Project **The Linnets, Clacton Road, Thorrington, Colchester CO7 8JW**

Title **Design Development from Pre-Application Advice Ref. 23/30154/PREAPP**

Date **12 February 2024**

DRAWING  
**PROP: FIRST ROOF AND ELEVATIONS**

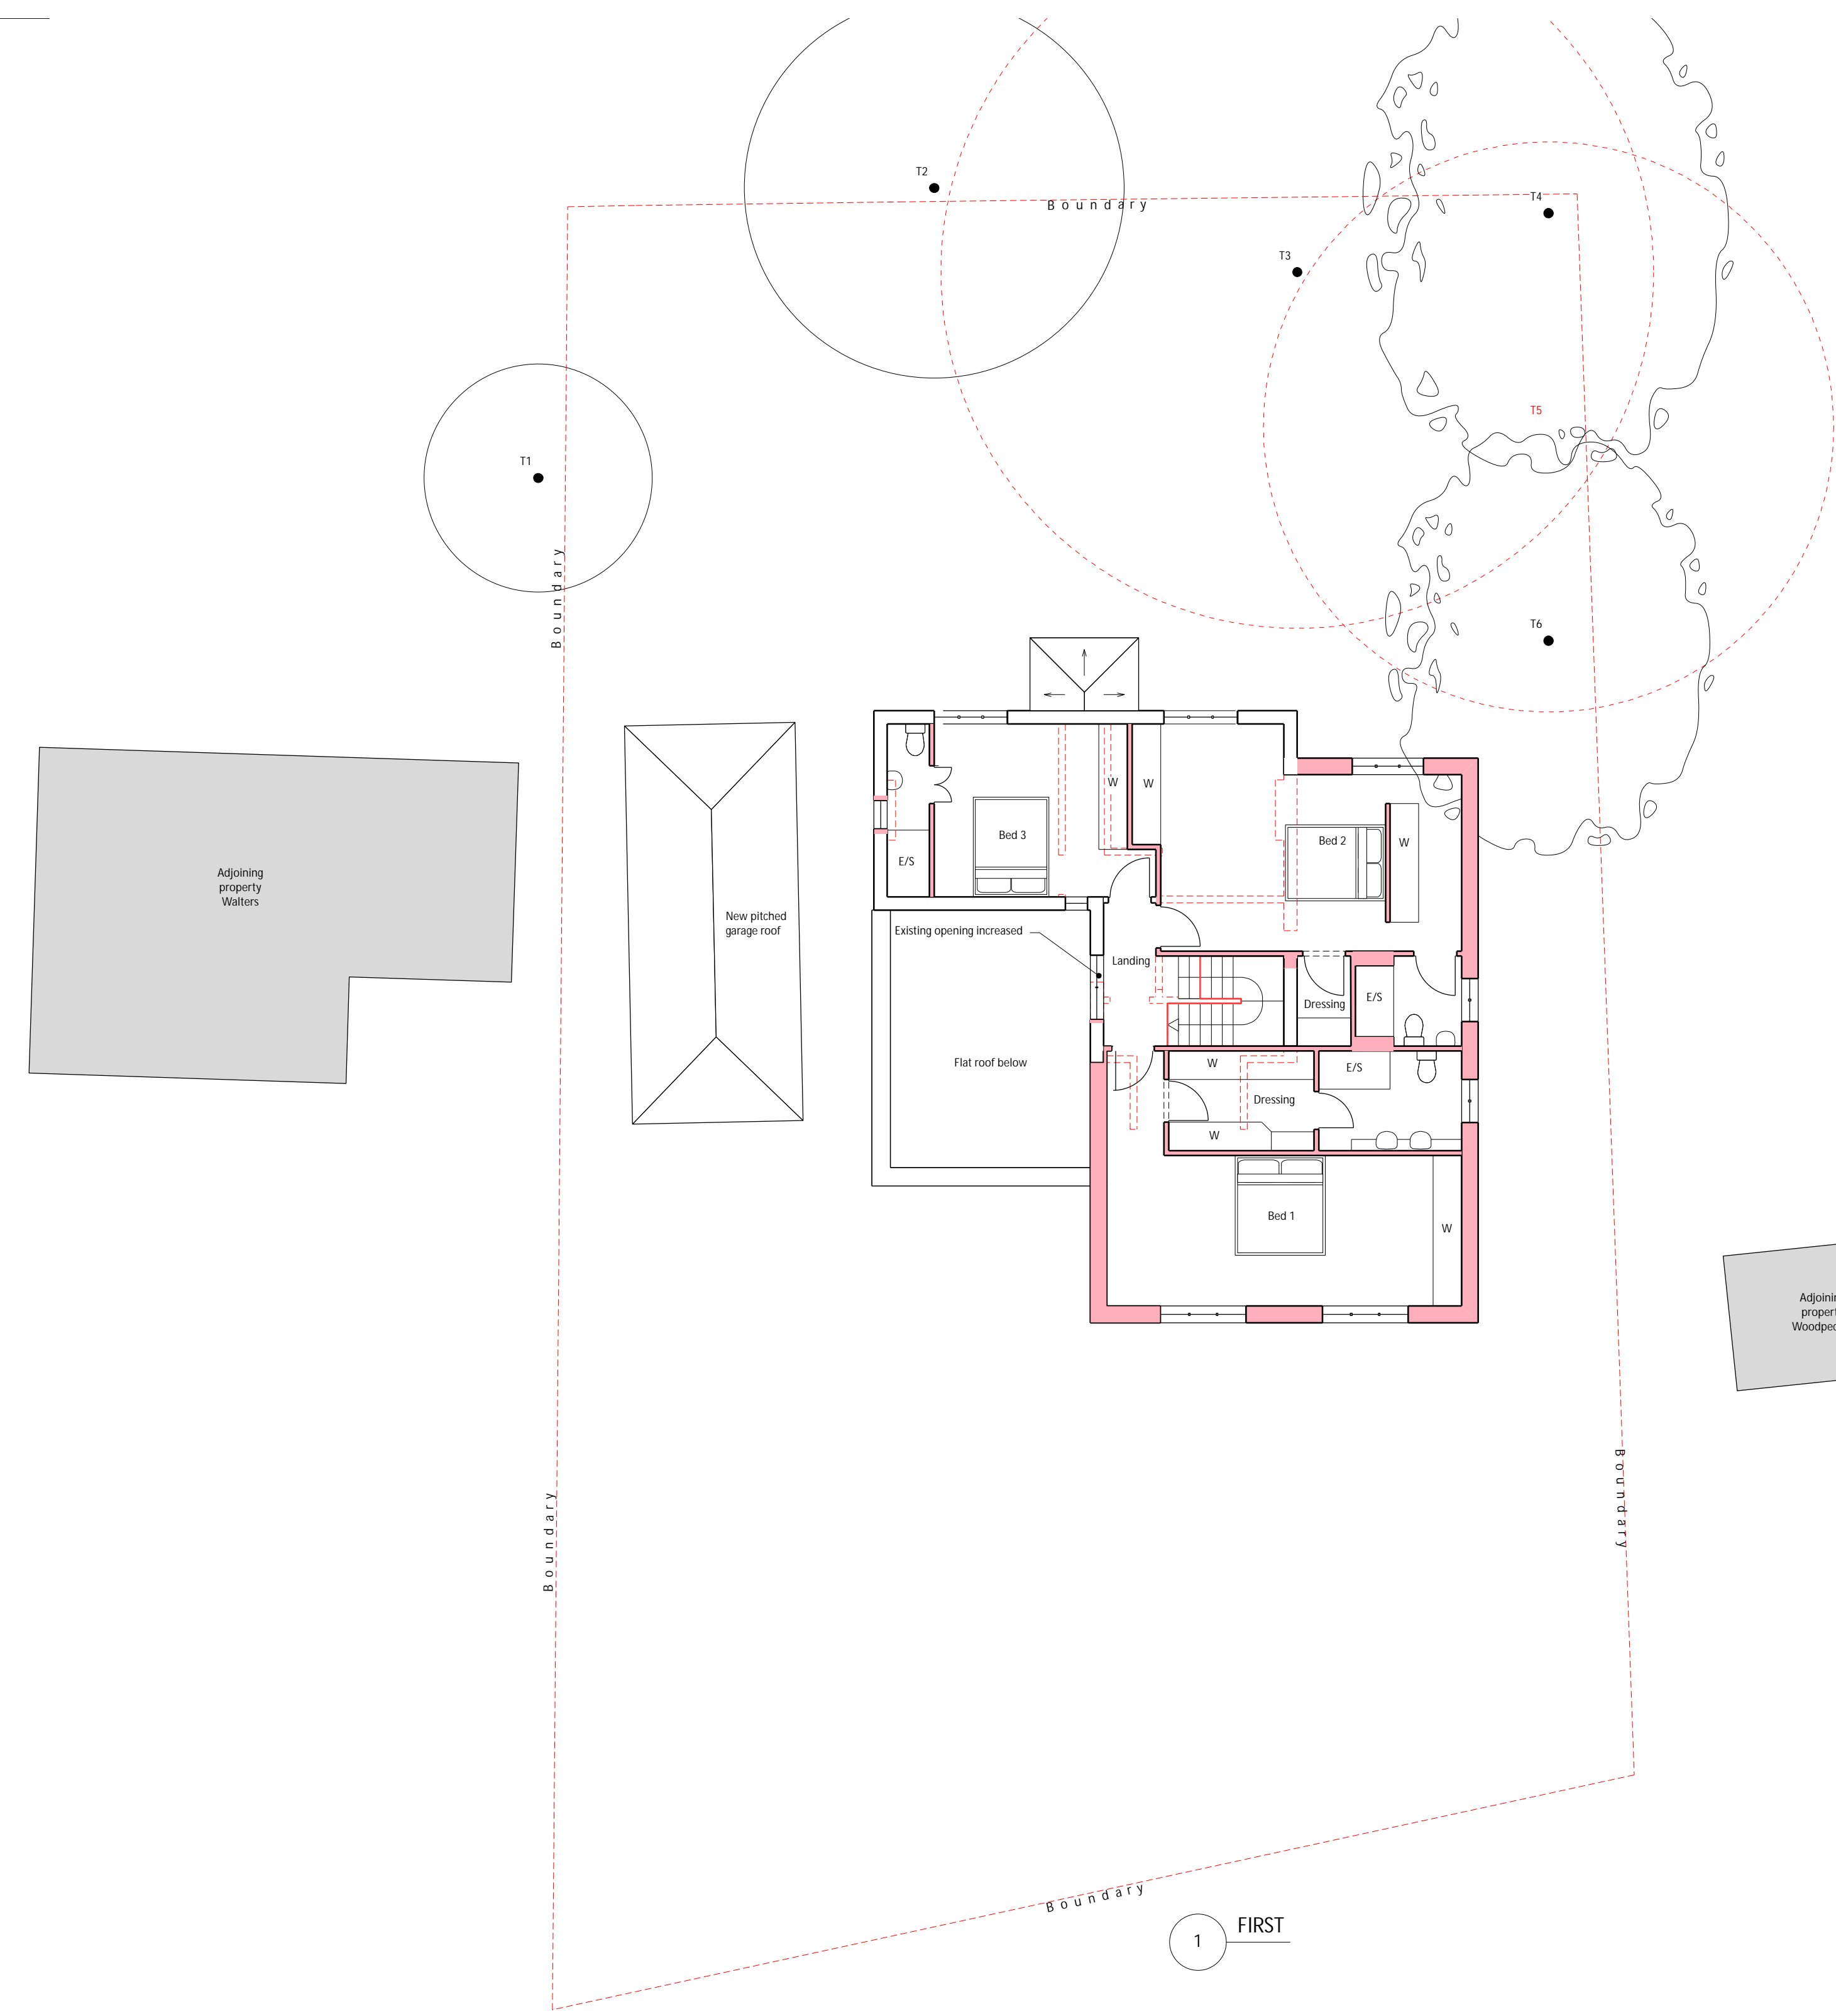
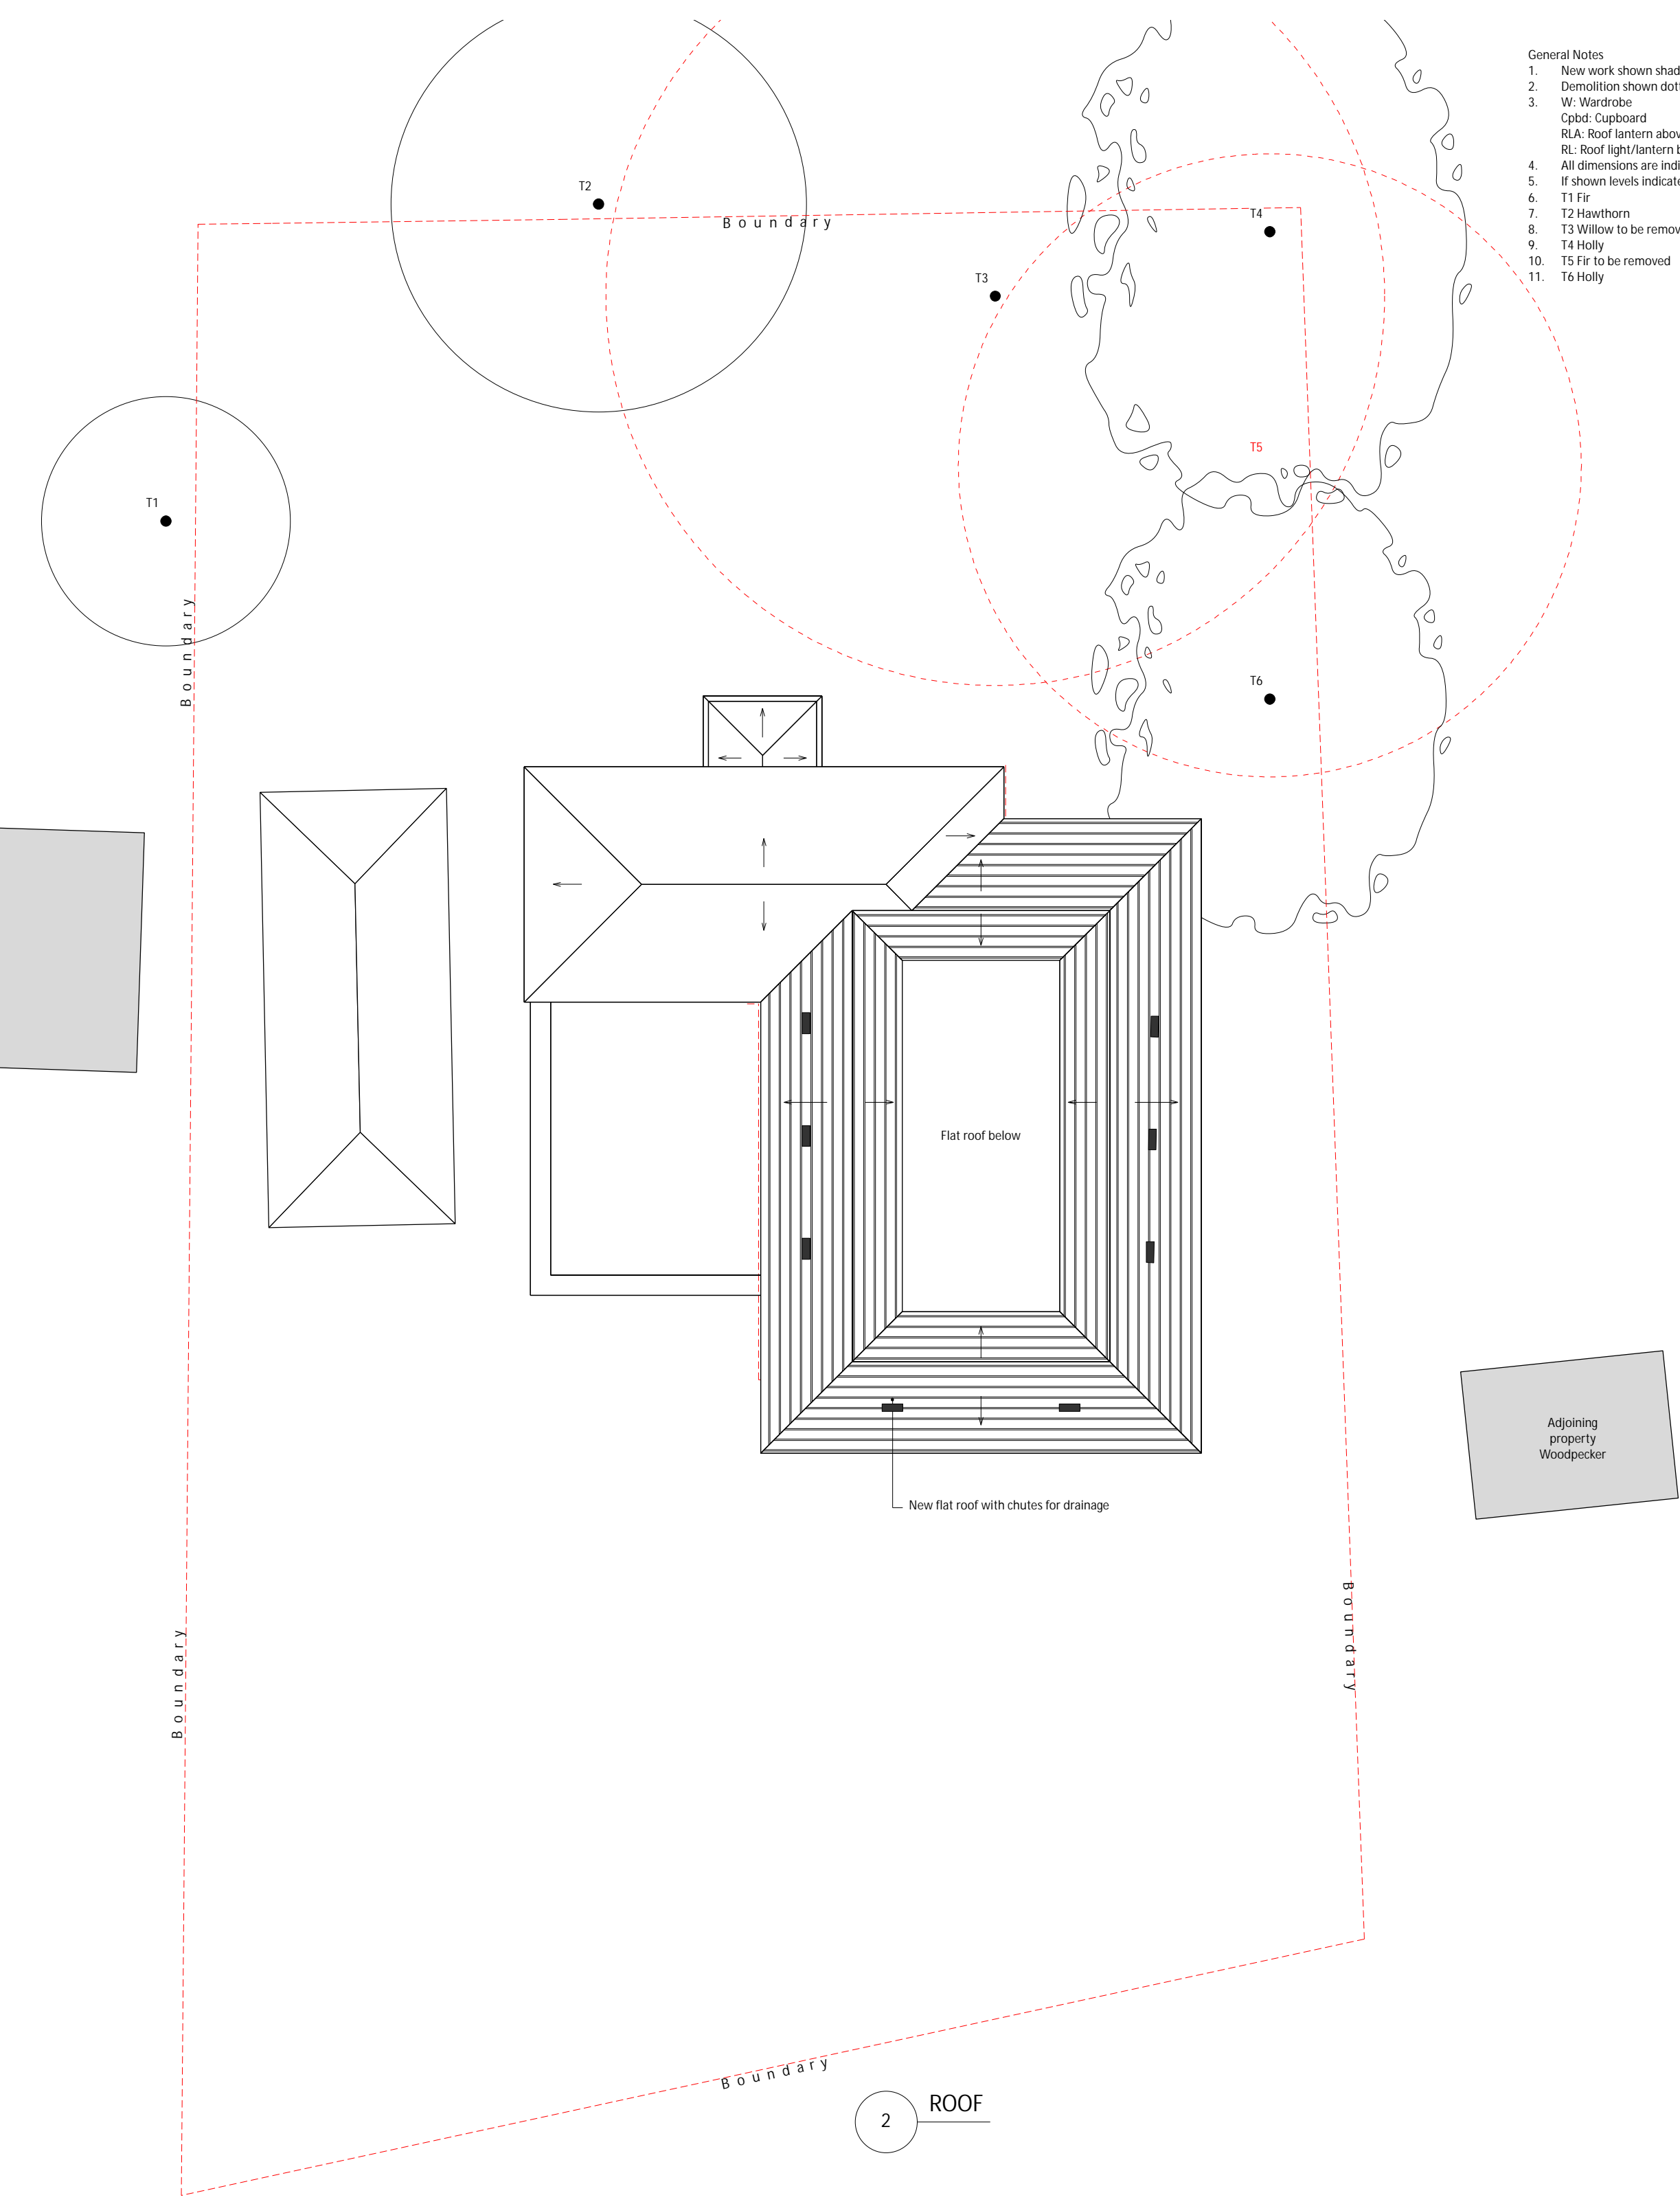
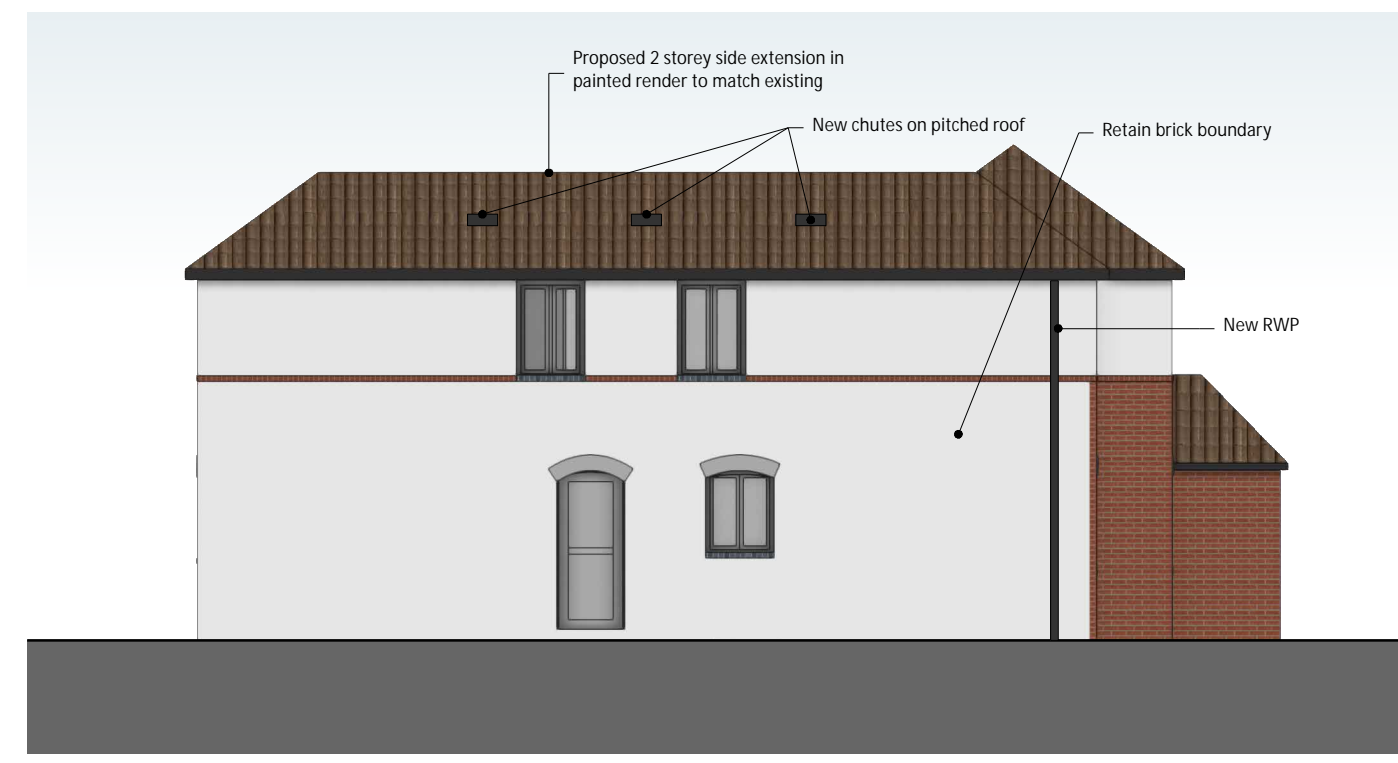
4	<p>The extension also will need to be moved back away from the front elevation of the house by approximately 1 metre so that the built form is subordinate to the main dwelling.</p>	<p>This has been incorporated into the application scheme,</p>
